COMMENTS ON APPELLANT'S STATEMENT

Planning Inspectorate Reference:	APP/T2350/W/25/3364202
LPA Application Reference:	3/2024/0642

**Retention of two unauthorised sheds with decking and fencing containing hot tubs in garden area
to front of hotel.**

Higher Trapp Hotel Trapp Lane Simonstone BB12 7QW

DRAWING
Proposed Hot Tub Enclosures

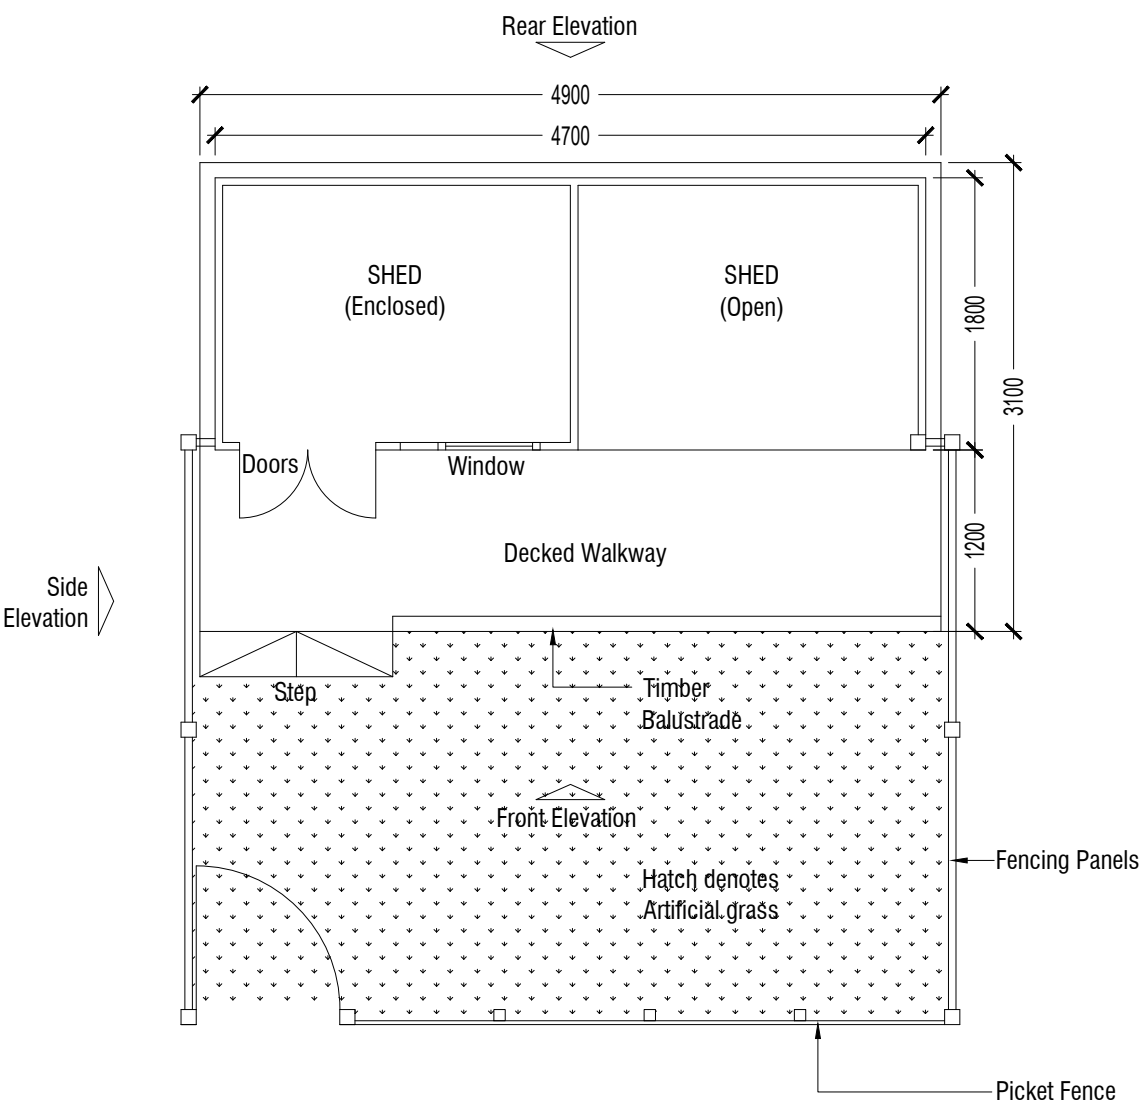
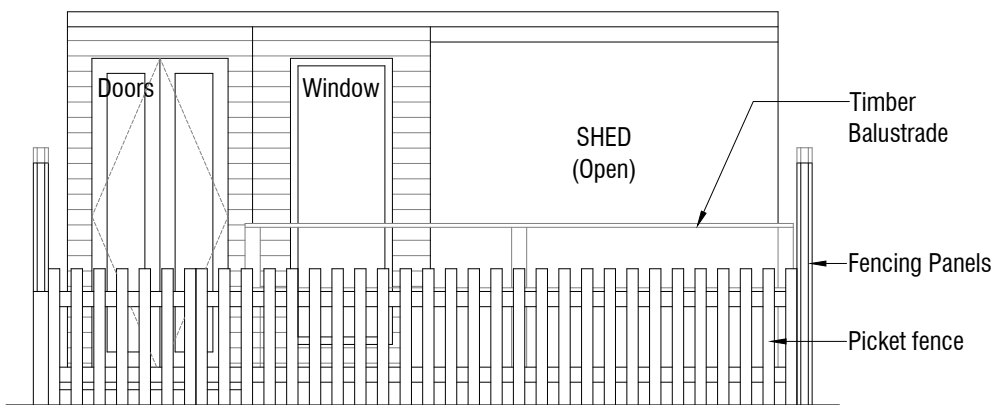
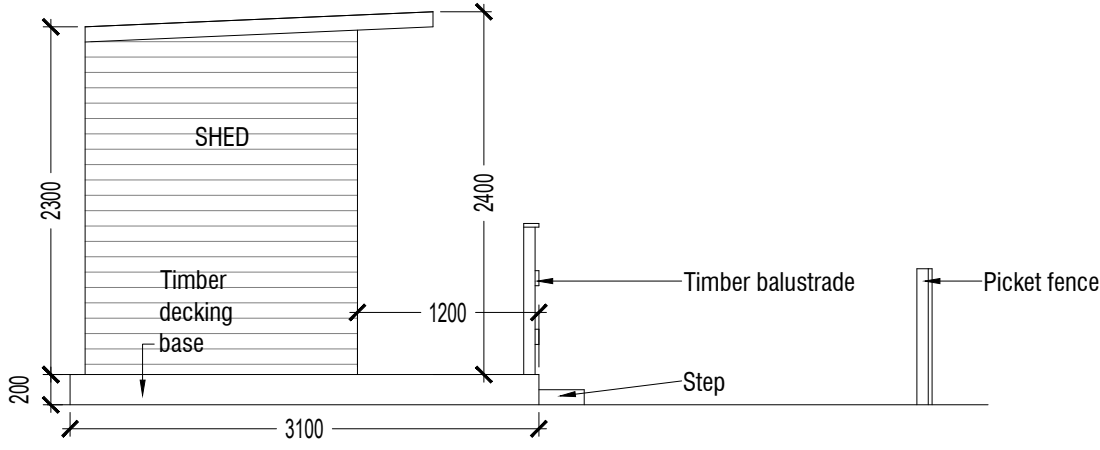
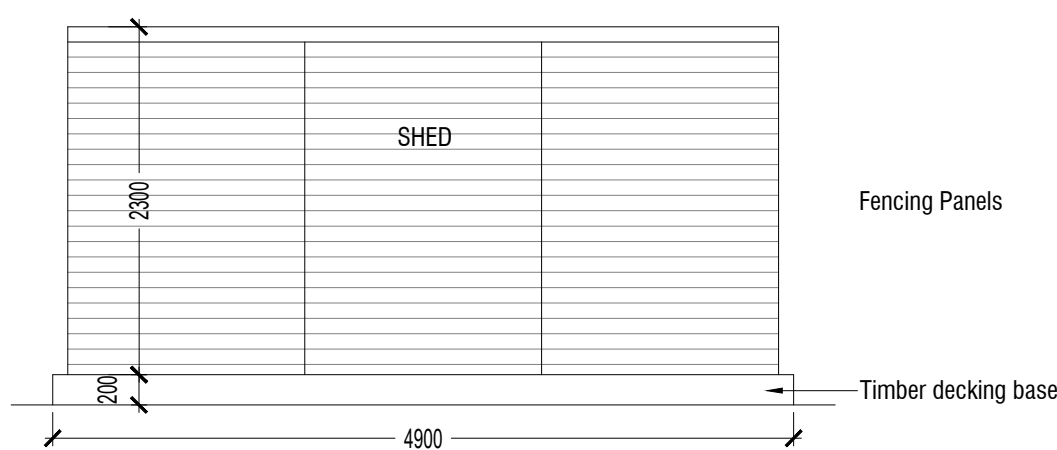
- 1.3 The overall design of the hot tub facilities is poor and does not relate well to the existing hotel and grounds in terms of quality of materials. The hotel is a public venue with the main building sited on a raised plateau overlooking the terraced gardens to the south with a raised terrace area which serves the public ground floor rooms including the restaurant, bar areas and function rooms. There also are private views from the adjacent residential units to the northwest which are sited on higher ground, albeit these are limited. The implication that any "temporary" structures should be permitted in any location which are of a poor quality and design is not accepted in terms of local and national policy. The fact that this development is within a publicly accessible setting within the open countryside compounds this harm. The ease of removal and storage is not a material planning consideration and due to potential impacts on the protected trees, removal and reinstatement in this location is not something that the LPA would advocate in indeed require. Hence if the structures were found to be acceptable then they should be erected and remain in place in order to avoid any unnecessary works within the Root Protection Areas.

- 1.8 With regards to permitted development rights it is correct that none have been removed from this commercial enterprise, however, those elements that could have been considered to permitted development were not included on the original plans and were added during the application process. Indeed, the original submitted plans did not include the fencing and artificial grass seating areas which were added to plan number C-0533-40 Revision B and submitted during the course of application. The revised plan shows that the timber balustrade

is attached to the decking and steps with the fencing attached to the sides of the shed which house the hot tubs/changing facilities and would therefore be read in conjunction with the structures and not a separate fence/enclosure.
